# CITY OF PORTLAND BUILDING PERMIT

Job ID: 2011-07-1652-ALTR

Job No: 2011-07-1652-ALTR 2011-12859-AMEND	Date Applied: 11/17/2011	CBL: 197- L-004-001	
Location of Construction: 93 WESTLAND AVE	Owner Name: CHAD THOMPSON	Owner Address: 93 WESTLAND AVE  PORTLAND, ME 04102	Phone:  207-749-7778
Business Name:	Contractor Name: Paul White	Contractor Address: Verrill St., Portland, ME	Phone:  207-650-4817
Lessee/Buyer's Name:	Phone:	Permit Type: BLDG - Building-amendment	Zone:  R-5
Past Use:  Single family	Proposed Use:  Same - Single family -- amend permit #2011-07-1652- adding <del>hall bath</del> & framing modifications <i>JB</i>	Cost of Work: 15000.00  Fire Dept:  <input type="checkbox"/> Approved <input type="checkbox"/> Denied <input type="checkbox"/> N/A  Signature:	CEO District:    Inspection: Use Group: R-3 Type: <i>SB</i> IRL-2009 Signature: <i>JB</i> 4/18/11
Proposed Project Description: 12' x 14' addition & extnsion od 2nd floor.		Pedestrian Activities District (P.A.D.)

RE: 93 Westland Avenue Renovation project

SK-1
1 OF 5

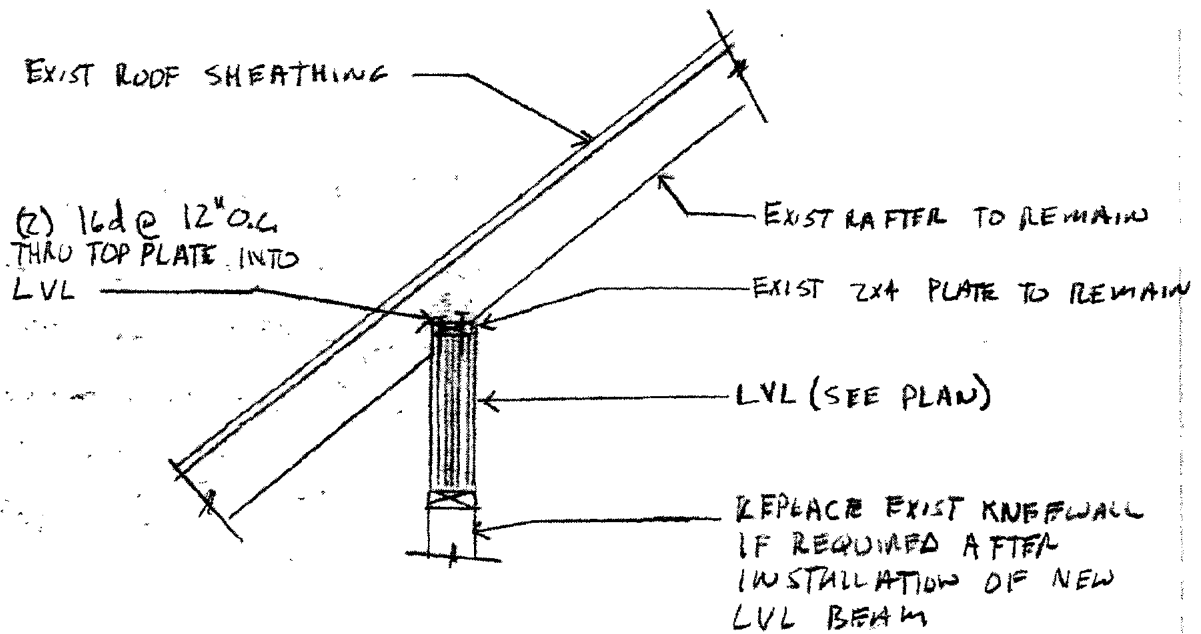
The first item I reviewed was a ridge beam running from the southwest side of the house (labeled Ridge Beam 3 on Sketch SK-1). The ridge beam is a 1 3/4" x 11 7/8" LVL, and spans approximately 23'-0". This existing ridge beam was found to be overstressed according to current building code requirements. It is recommended that the contractor install a vertical support to reduce the span of the ridge beam to meet current building code requirements. The installation of this support is detailed on the attached sketches.

SECTION Z
3/4" = 1'-0"

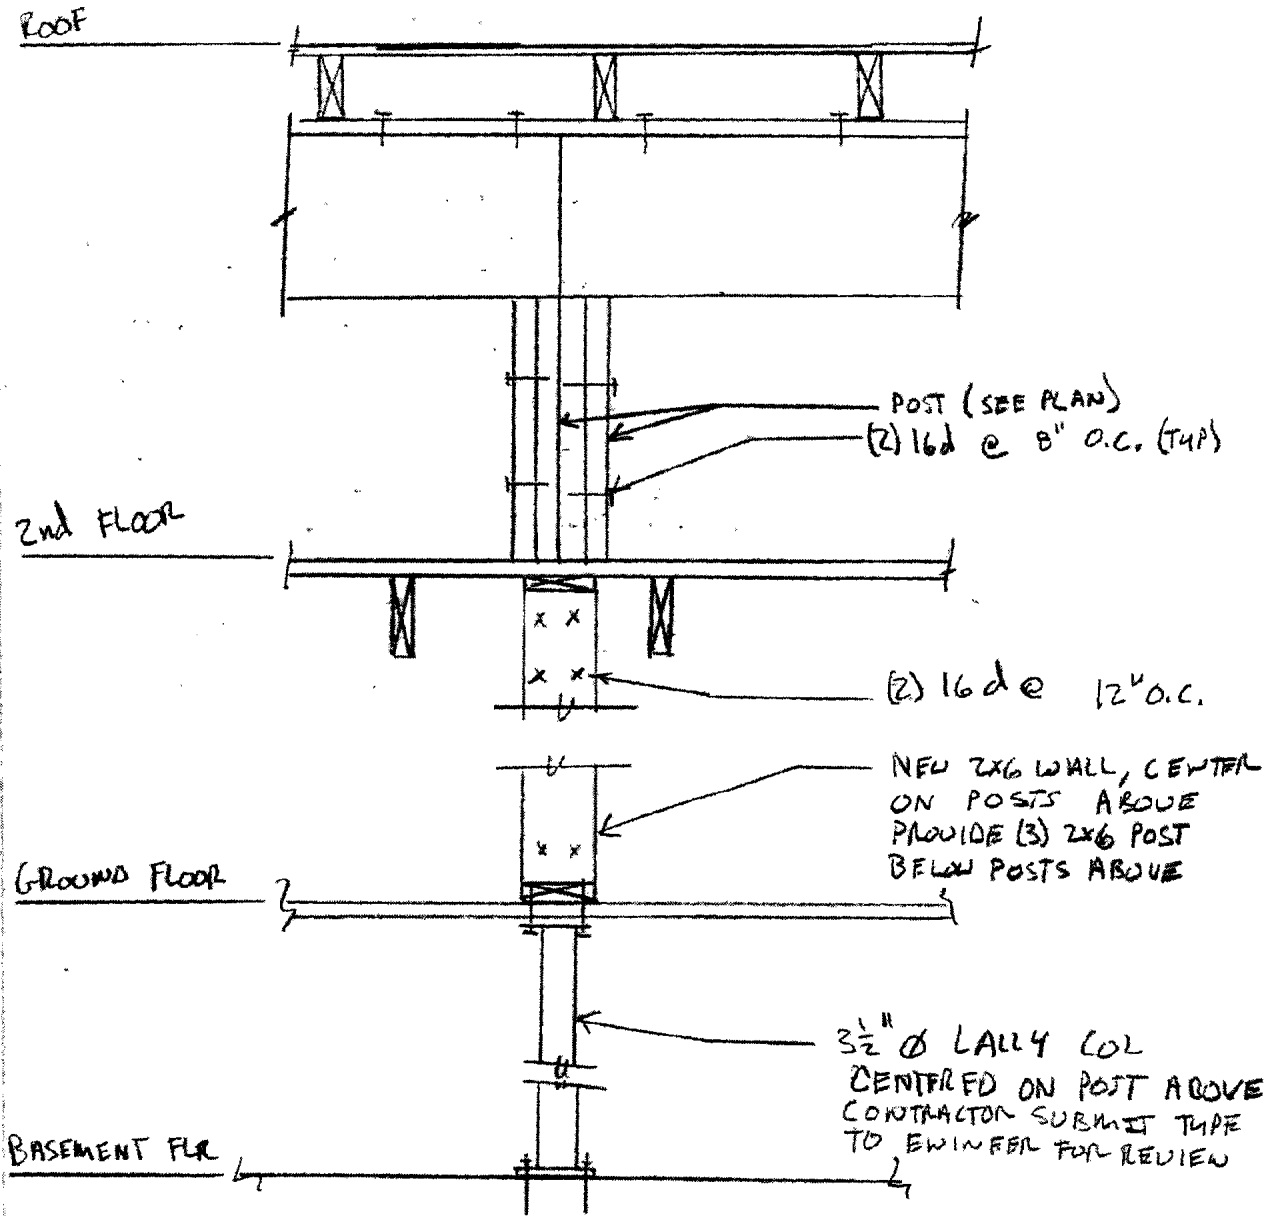
The second issue I reviewed was the roof rafters on the North side of the building. The original roof was reportedly lifted at the ridgeline to allow for more living space on the second floor. The rafters currently bear on the exterior wall at one end, a new knee wall at center span, and a new ridge beam at the other end. The new knee wall at center span is supported by the second floor framing. New rafters were sistered alongside the existing rafters to span from the knee wall to the center ridgeline. Upon review of this framing for code compliance, I found that the floor below the knee wall lacked the structural capacity to carry the roof loads from above. I recommend removing the existing knee wall and installing two LVL beams to remove the roof load from the existing floor framing. Details of this recommended repair are shown on the attached sketches.

SK-3
3 OF 5

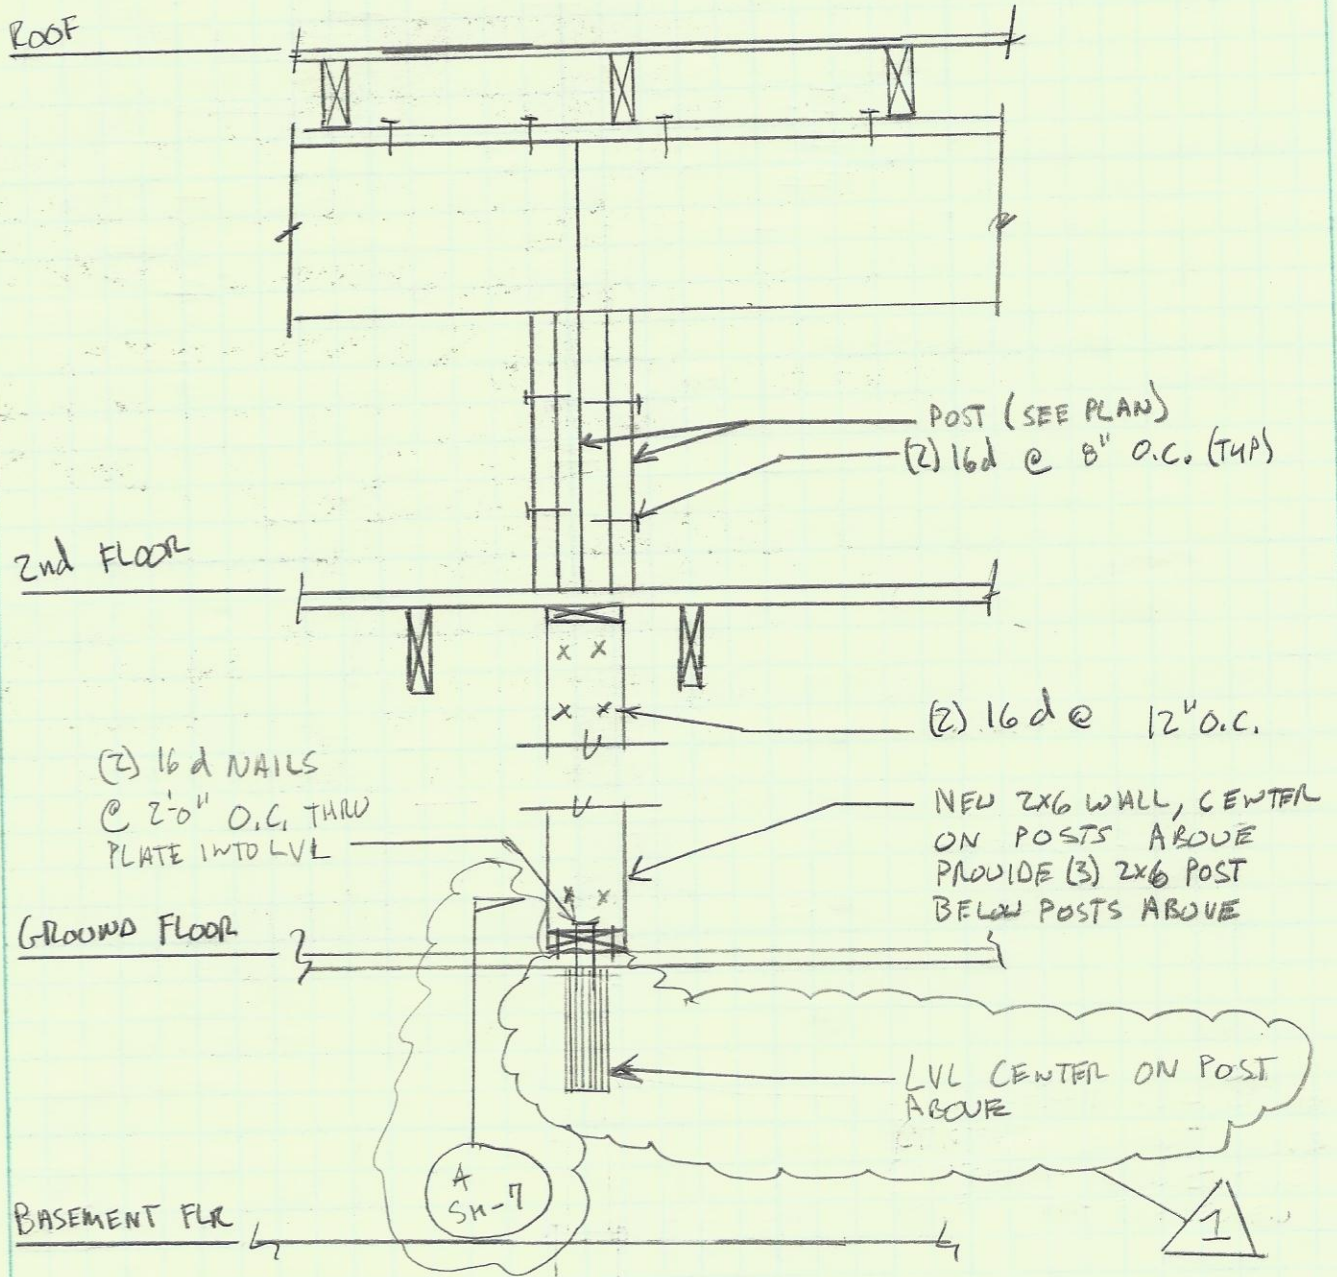
Please find an engineer's drawing describing the posting of the LVL in the upstairs that was added to support the building's original roof at the kneewall. This modified drawing now includes an additional LVL and Simpson hanger in the basement that we decided to add so that the lolly column posting could be moved to the center-line of the building.
